From: Maria O'Donnell <MODonnell@cityofsydney.nsw.gov.au>
Sent: Friday, 10 August 2018 2:58 PM
To:
Cc: Vanessa Aziz
Subject: SSD 7317 - Modification 12 - ATP, Eveleigh - City of Sydney Response

Thank you for the opportunity to provide comments on Modification 12 to SSD 7317. It is understood that the changes include the following:

Figure 1 Public Domain Staging Plan

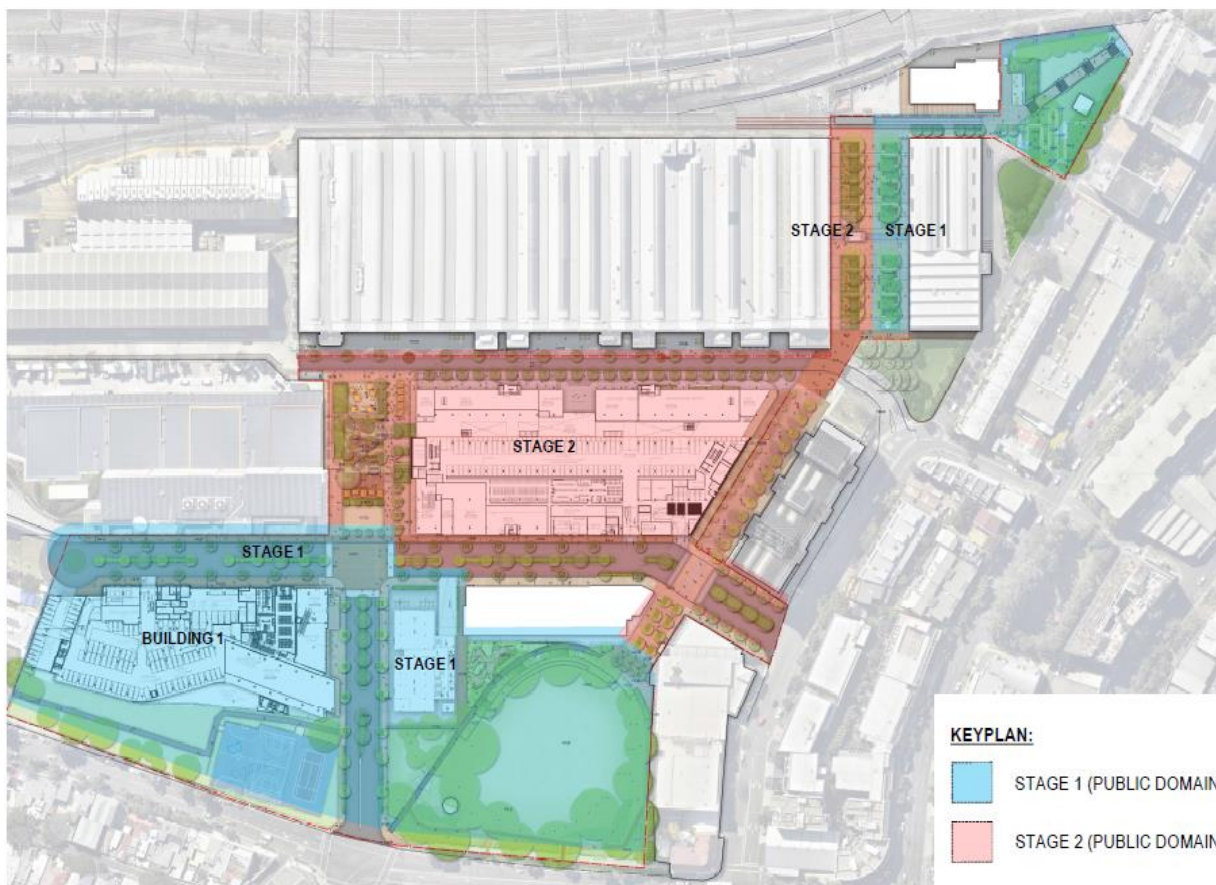
- i. It is recommended that the works to the new Indigenous Garden are specifically included into Public Domain Area 2. As per condition B53D, works to Public Domain Area 2 are to be completed prior to the issue of the first OC for Building 2. This timing is consistent with delivery of the Stage 2 Heritage Interpretation Plan. If the subject modification is to be approved, the Department are recommended to require the proponent to formally amend the Public Domain Staging Plan to incorporate the new Indigenous Garden for the avoidance of doubt.

Garden is now included in the area defined as Public Domain Area 2, and the Staging Plan that forms the package of information for Public Domain Area 2 is amended to reflect the addition of the Indigenous Garden. By incorporating the Indigenous Garden into the condition, the same level of detail that was required for the rest of the landscaping and public domain areas in the precinct will also be provided for the Indigenous Garden and be subject to consultation with the city. Further, the above change will ensure that the Indigenous Garden is captured by the requirements of the rest of the associated conditions i.e. B53C and B53D.

Figure 2 The proposed modification to Indigenous Garden
 Source: Aspect Studios

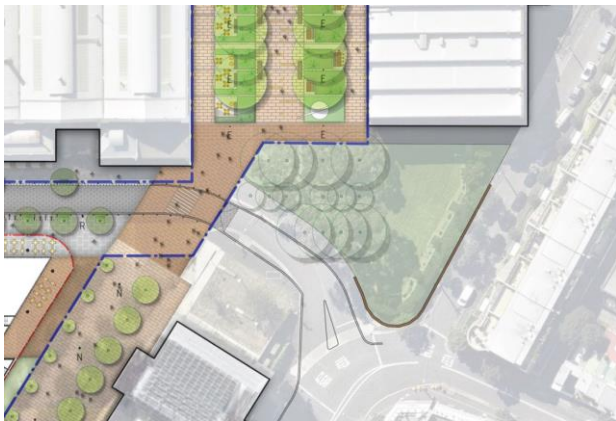
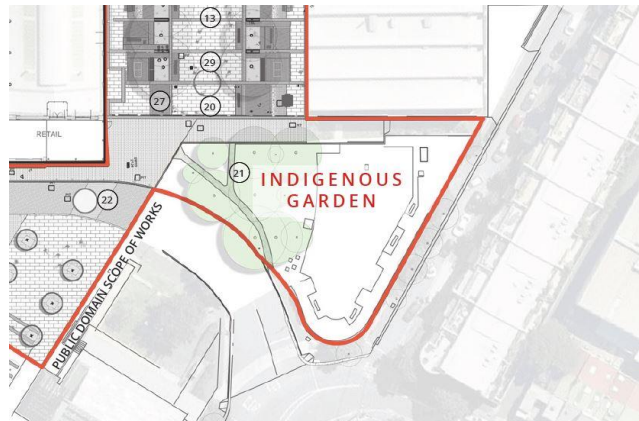
1. It is unclear whether the new Indigenous Garden will form part of the landscaping and public domain works to be completed under Public Domain Area 1 or Public Domain Area 2?

Figure 4 The proposed wellness and skate/scooter park
 Source: Aspect Studios

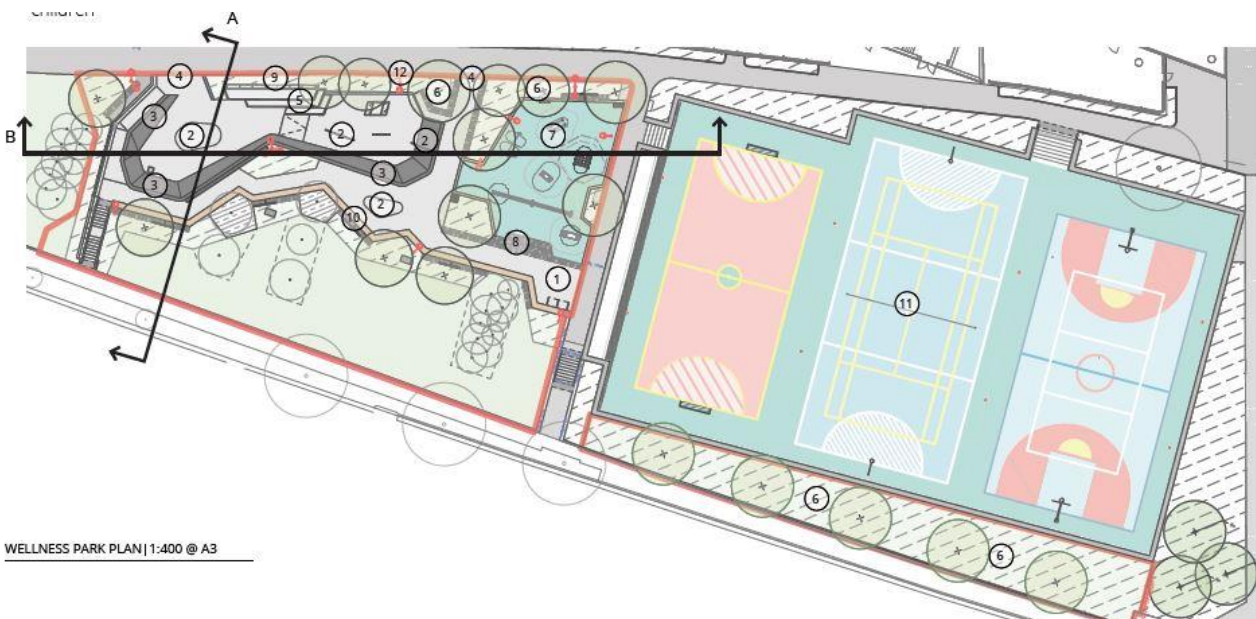
3. The concept design for the Wellness Precinct appears generally acceptable however, it is unclear what the grey hatch lines mean within the grassed area to the south of the scooter/skate park. It should be clarified what is on soil and what is on slab.

4. Given that this area is likely to be regularly frequented by children, there is no indication what security gates or the like are within or around the scooter/skate park. There is a steep fall towards Henderson Road. How is access into and out of this area of the precinct managed to ensure small children do not wander into the surrounding streets.

5. It is noted that there are shade trees around the perimeter of the scooter/skate park however, the scooter/skate elements are quite open and not protected from the sun. Are additional shade structures or the like required in the mounds etc. given that small children will use it for potentially prolonged periods? This is a consideration akin to play areas at child care centres or the like.

EVELEIGH GREEN LANDSCAPE PLAN | 1:400 @ A3

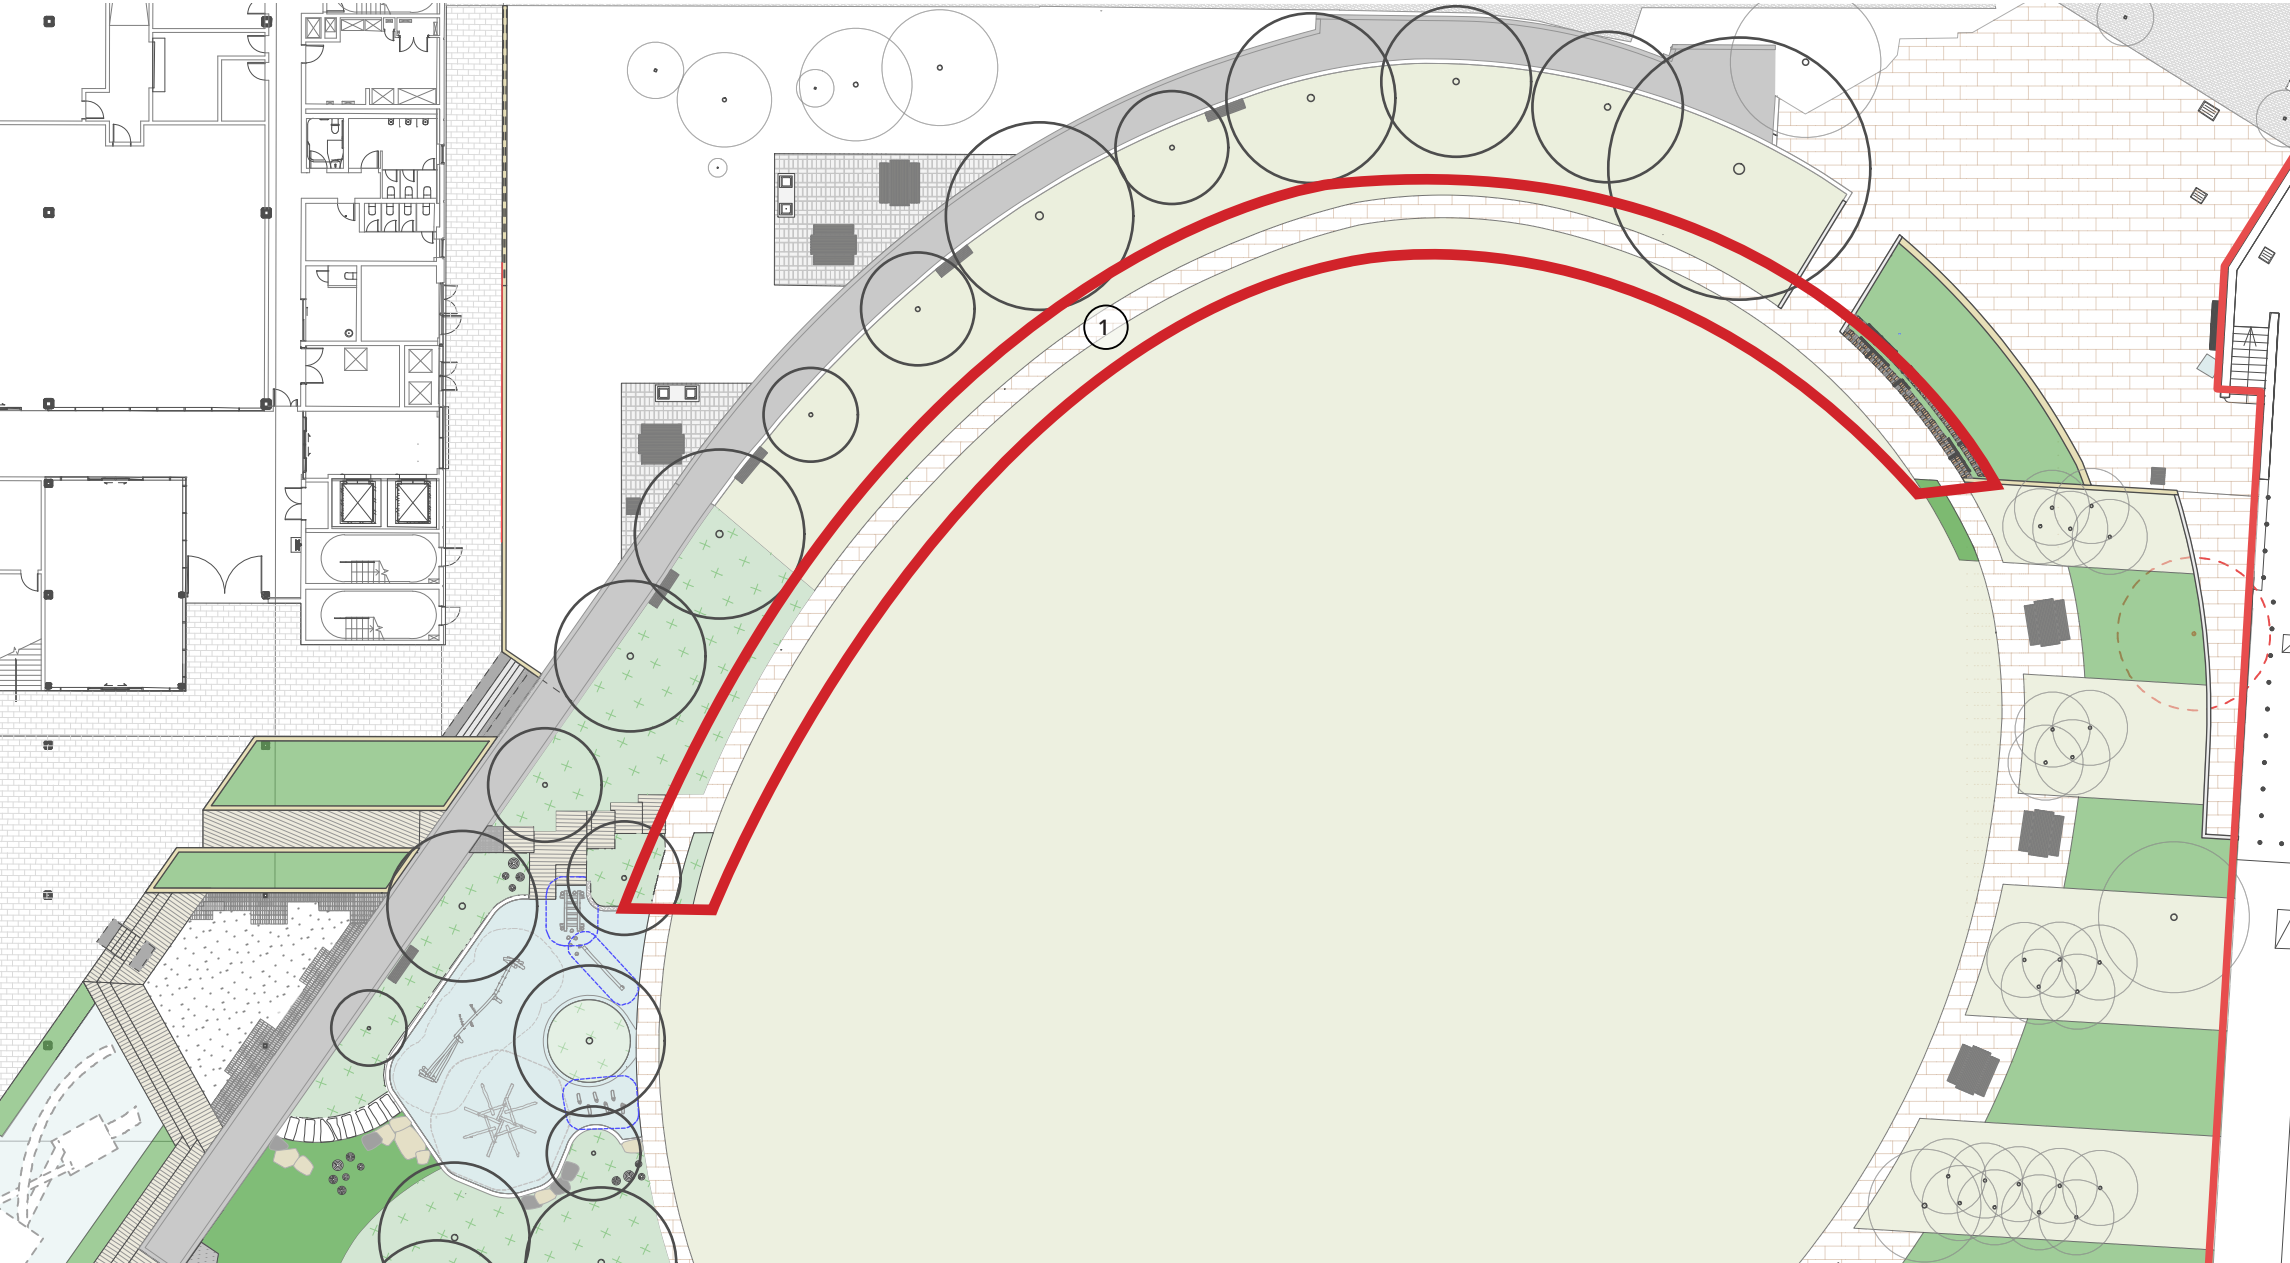
7. The concept proposal appears to be acceptable. However, as per above, the City objects to the proponents request for the more detailed drawings of Eveleigh Green to be submitted to the PCA for final approval. Eveleigh Green is within PD Area 1. Any detailed drawings including future amendments to the approved PD Area 1 package should either be assessed via the subject application with sufficient detail provided for assessment, or re-satisfy the condition via the consultation process with the City and the Heritage Council as required by the wording of Condition B53A for resubmission to the Secretary.

# LANDSCAPE FEATURE LIGHTING

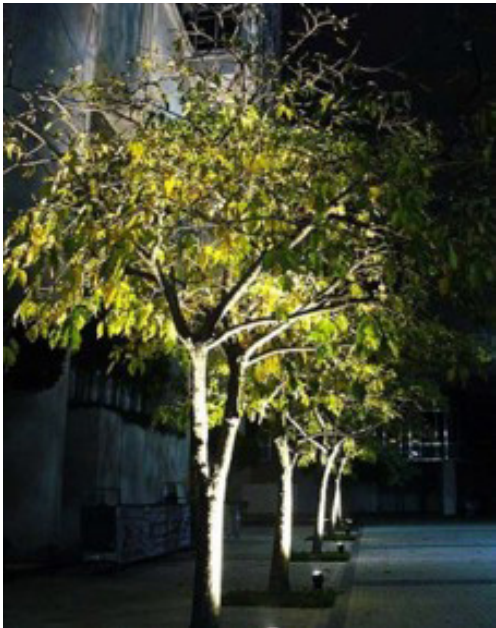
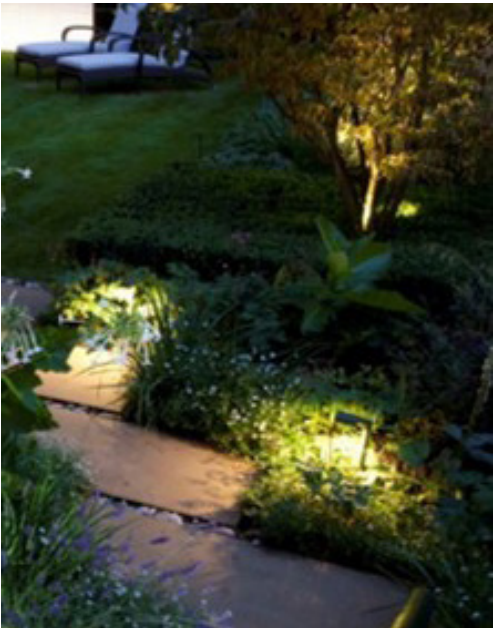
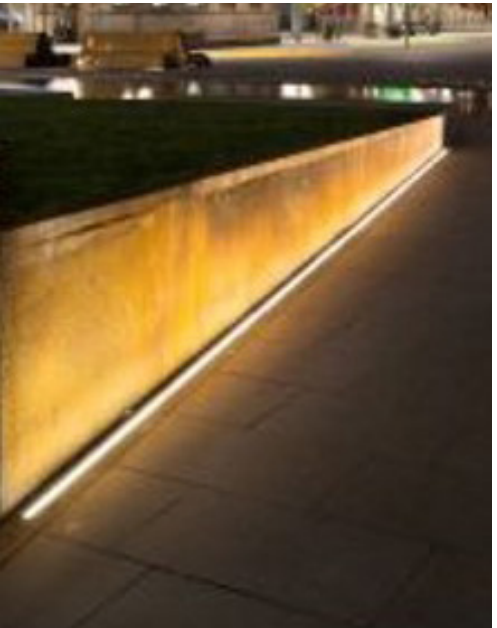
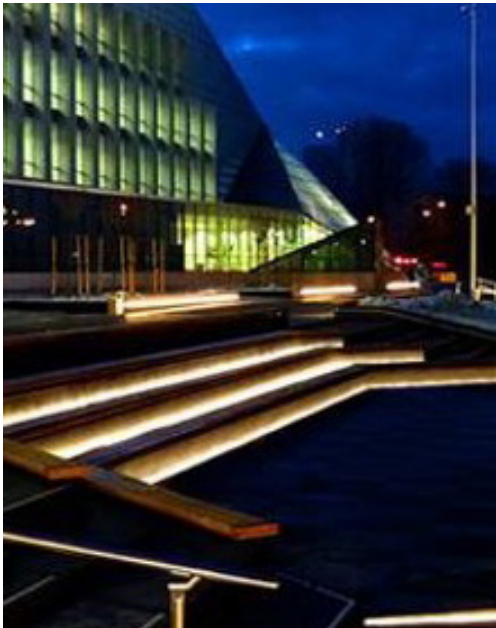
8. The City objects to the proponents request for the detailed designed documents of the 'Feature Lighting Concept' to be submitted to the PCA for final approval.

- i. The City's Lighting Engineer has specific knowledge to assess the relevant details to ensure that they meet the Sydney Streets Technical Specifications A5: Street Lighting Design [Link here](#) , and the Sydney Lights Public Domain Design Code [Link here](#) .

- ii. The proponent has stated that they intend to include the detailed designed documents of the 'Feature Lighting Concept' for the Public Domain within the Stage 2 Heritage Interpretation Plan. Any additional details or amendments to the approved PD Area 1 and 2 packages that relate to the lighting should either be assessed via the subject application with sufficient detail provided for assessment, or re-satisfy the condition via the consultation process with the City and the Heritage Council as required by the wording of Condition B53A for resubmission to the Secretary.
